8 September 2021

NSW Department of Planning, Industry & Environment

RE: Weigall Sports Complex, Sydney Grammar School (SSD-10421) - Request for information (impact on views/outlook)

1 EAST ELEVATION

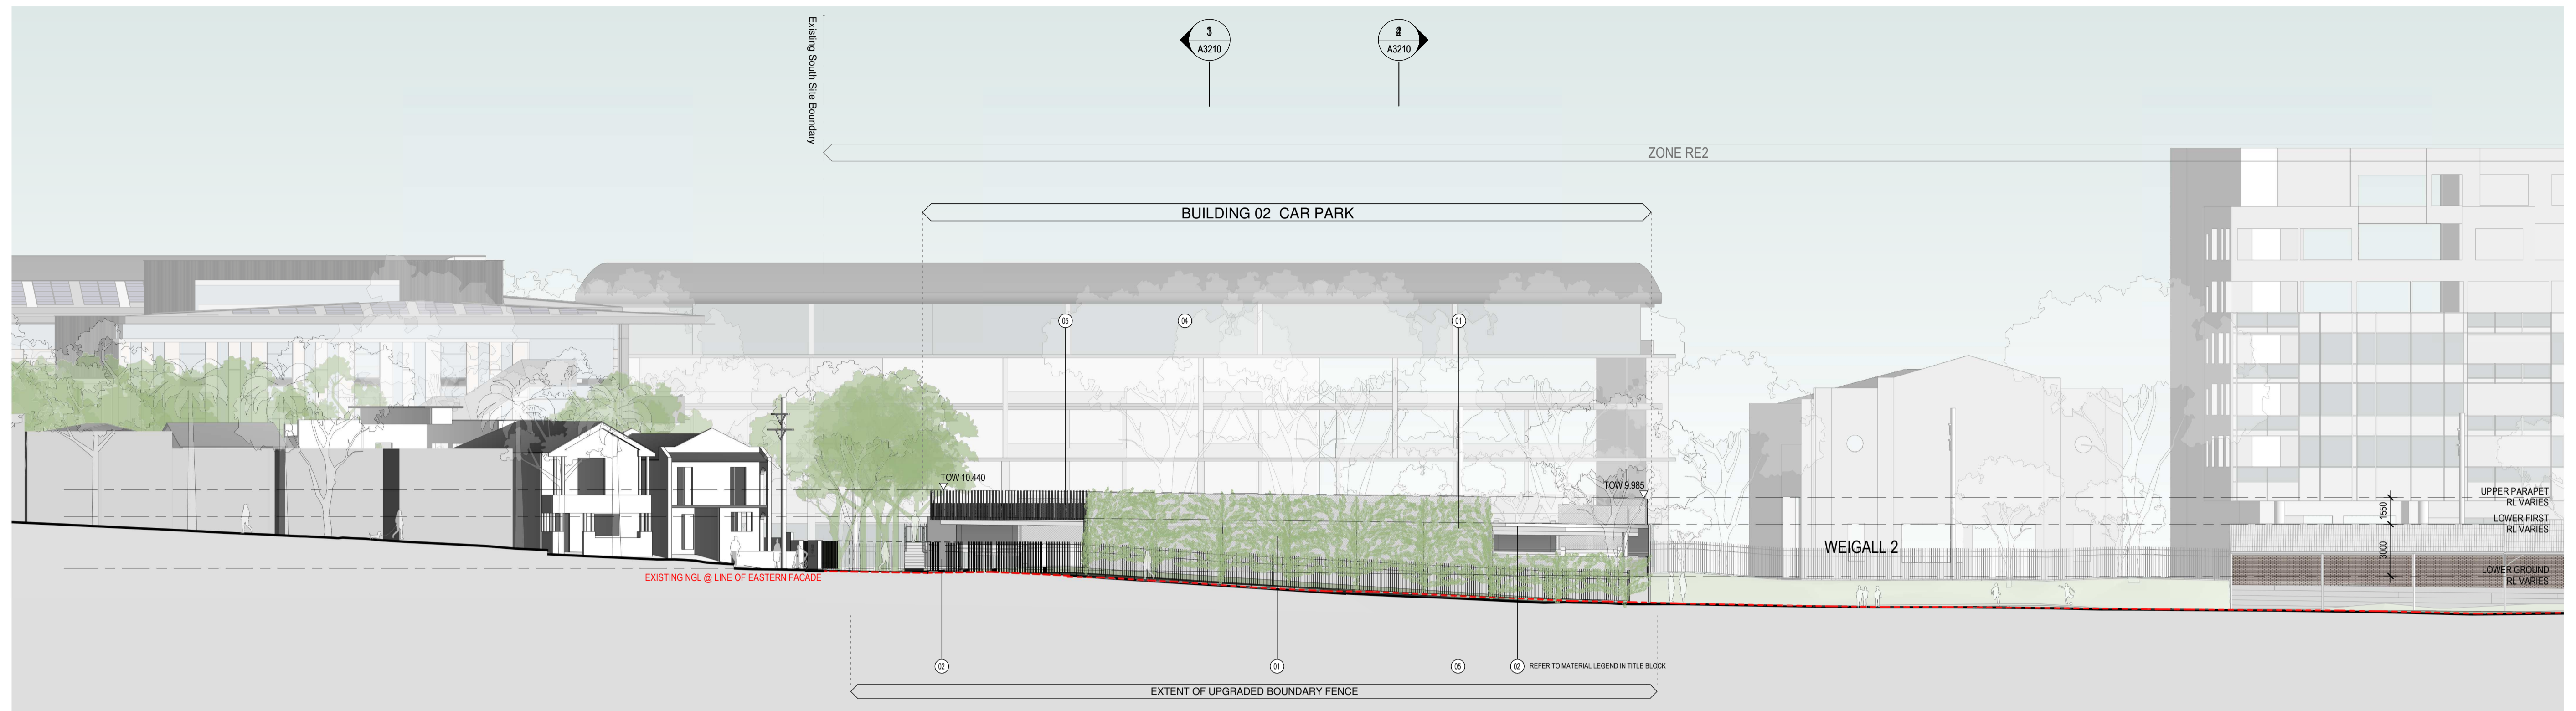
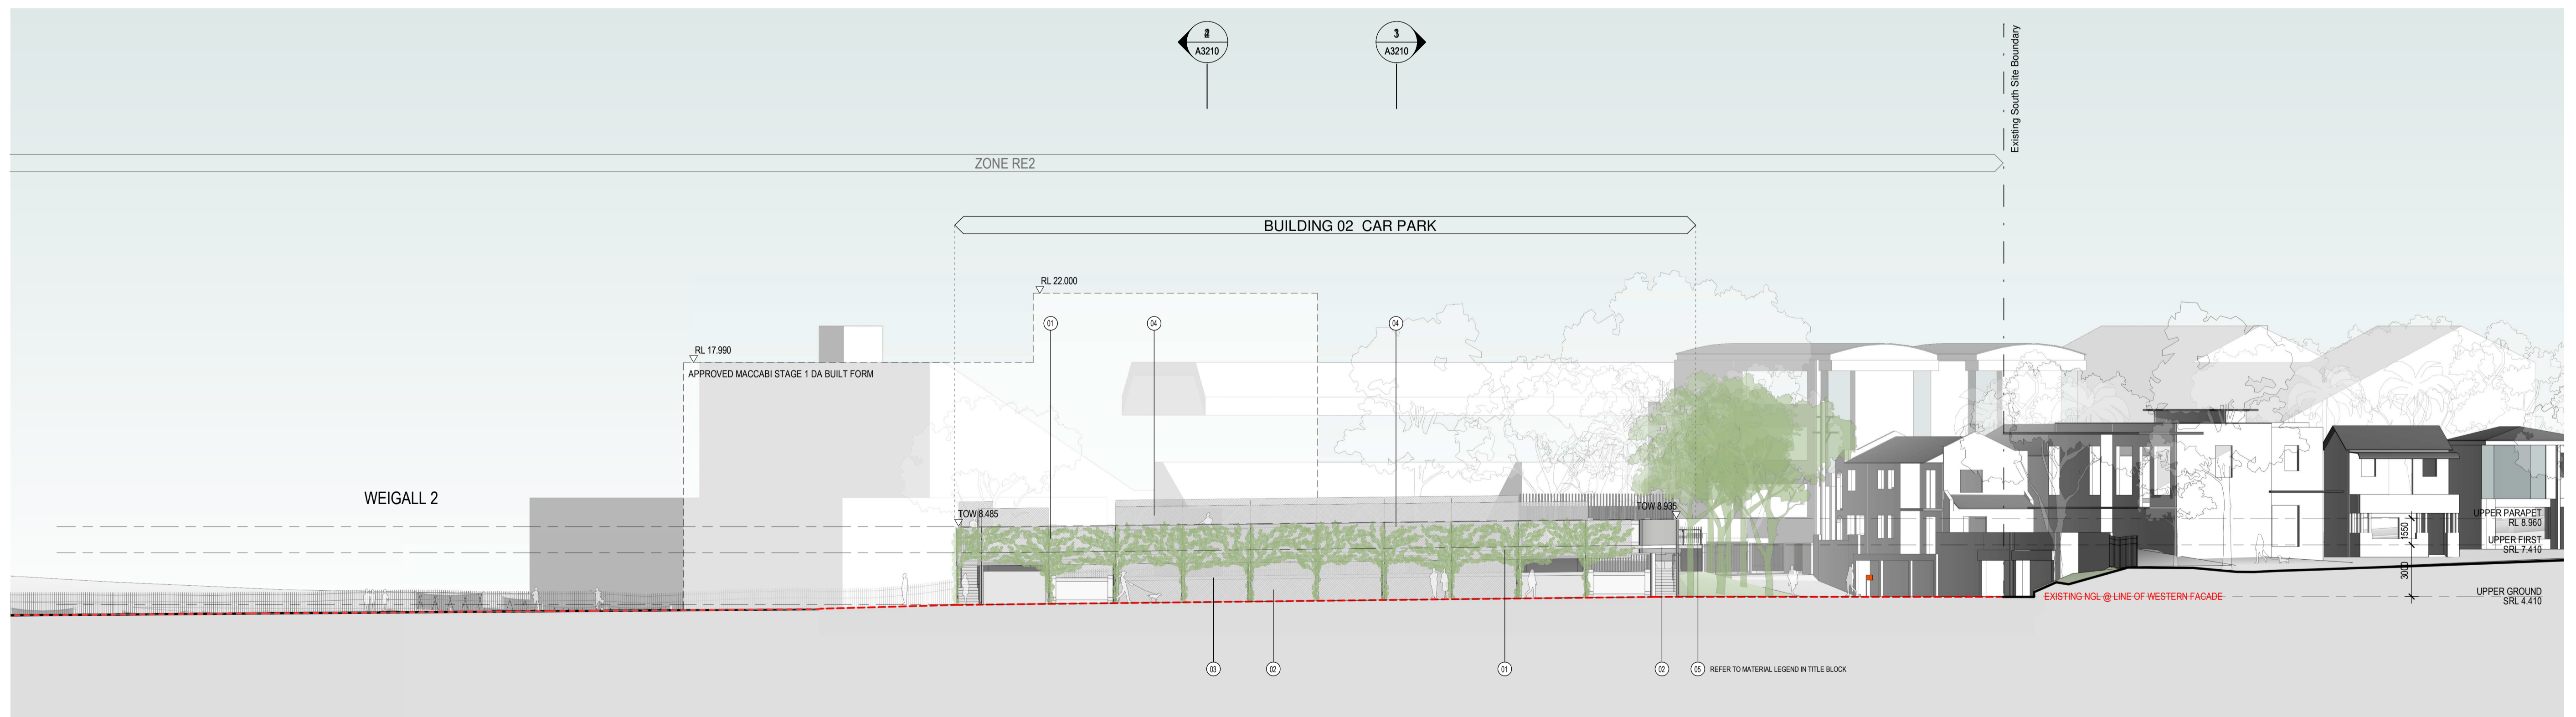
- A Woollahra LEP 2014 compliant building at RL 17.22 would obstruct all views/outlooks from north facing units at 8 Vialoux Avenue noting that the affected windows are well below this height (see **Figures 2 and 3** below). As a fully compliant residential flat building would have a severe/devastating impact on the view/outlook from north facing units at 8 Vialoux Avenue, the proposal and its view/outlook impact is considered to be predictable and reasonable. The survey information used to prepare **Figure 2** is attached.

- iv. These generous side and front boundary setbacks open up a wide north-eastern view cone for Units 1, 4, 5, 8, 9 and 12 at 8 Vialoux Avenue (see **Figure 4**). The proposal would also provide a spacious and attractive green outlook for these units noting that the proposed landscape plan includes low/high level planting and draft condition B14 requires 42 new trees with 200 litre pot sizes and no less than 31.7% of the site area to be tree canopy. It is considered that this design and siting constitutes a skilful design. When compared with the sightlines afforded by a compliant residential flat building (see **Figures 3 and 5**), the proposal is considered to be eminently reasonable.
